Planning Application Ref: LU/342/18/DOC

Location: Windroos Nursery And Land Adjoining Worthing Road, Littlehampton BN17 6LY

Description of works: Approval of details reserved by condition imposed under ref LU/229/10/ relating to Condition No 16 all the existing trees/bushes/hedges to be retained on the site have been protected by a fence.

Tree protection plan

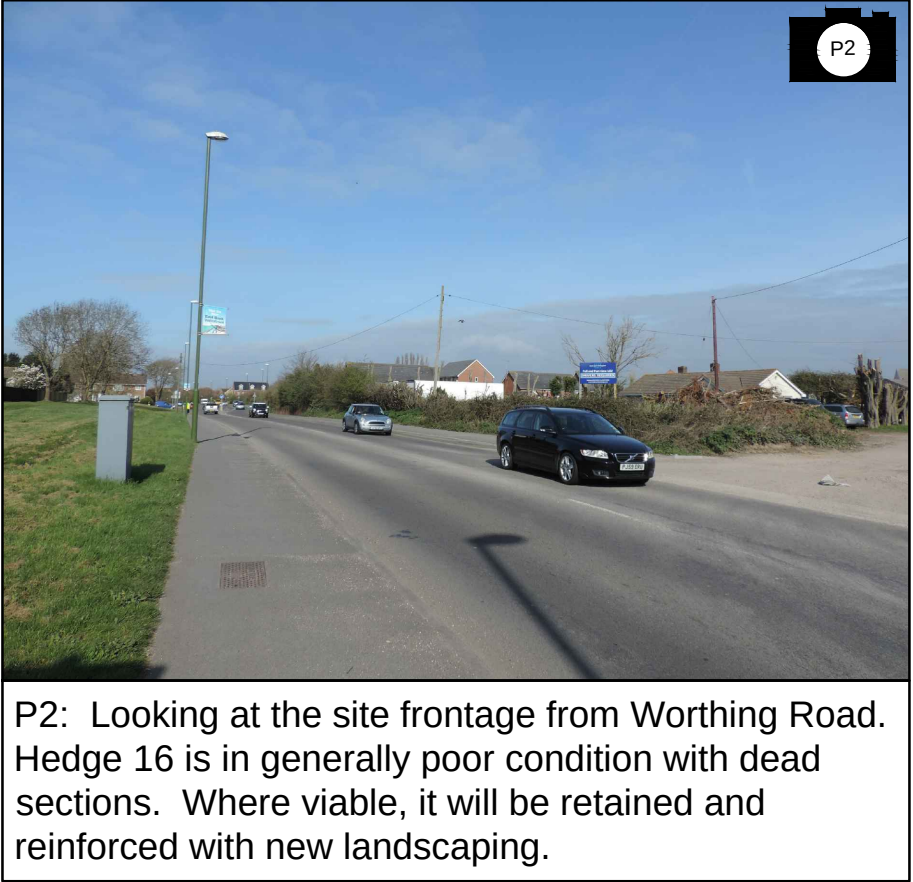
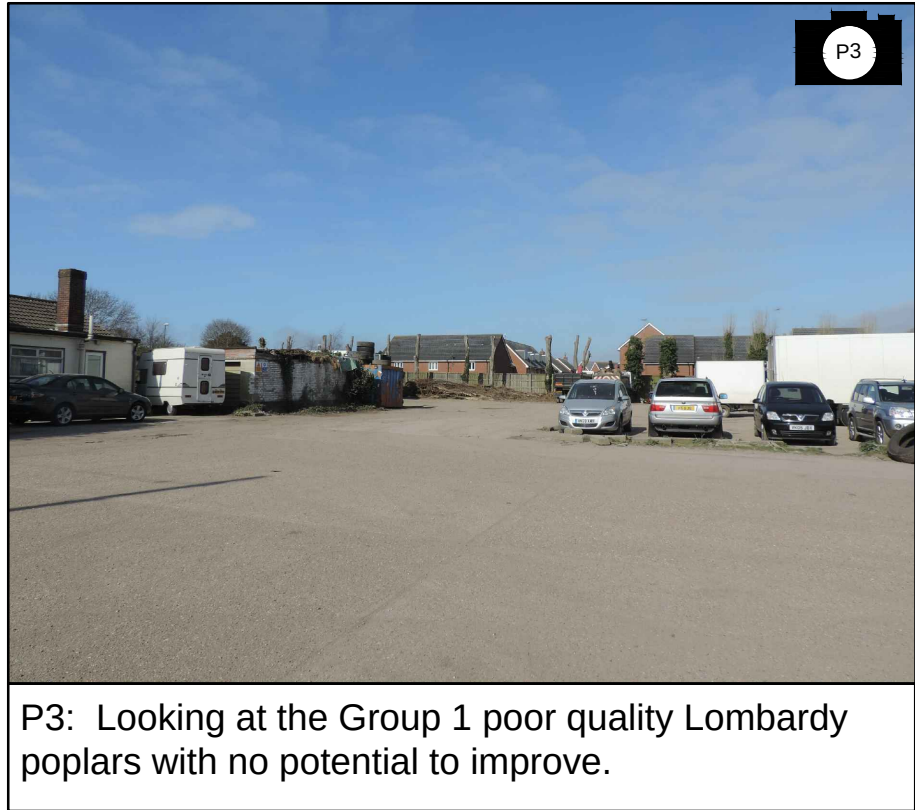
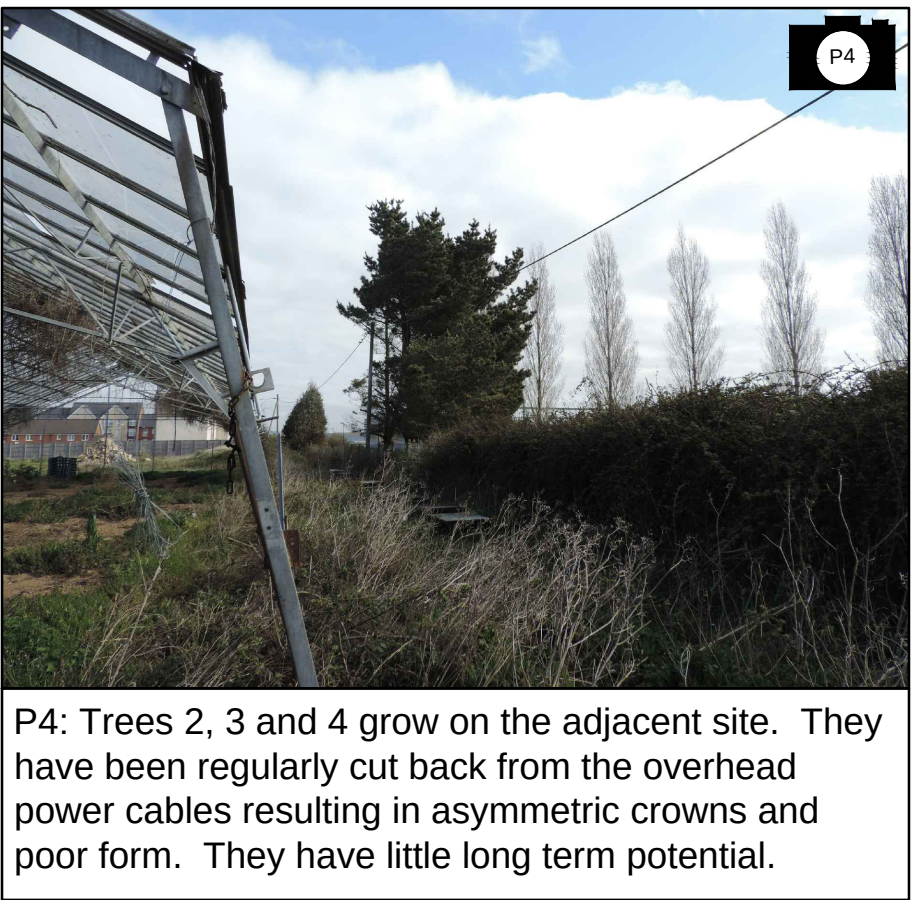
- The majority of tree protective fencing was seen to be ‘fit for purpose’ and in accordance with the aforementioned plan. A minor but not insignificant anomaly was observed at the southern end of the protective fencing area around tree nos T2-T4 (see photos). I would expect the applicant to instruct their contractor to attach an additional HERAS panel to the scaffold framework, so as to complete and create an effective construction exclusion zone.
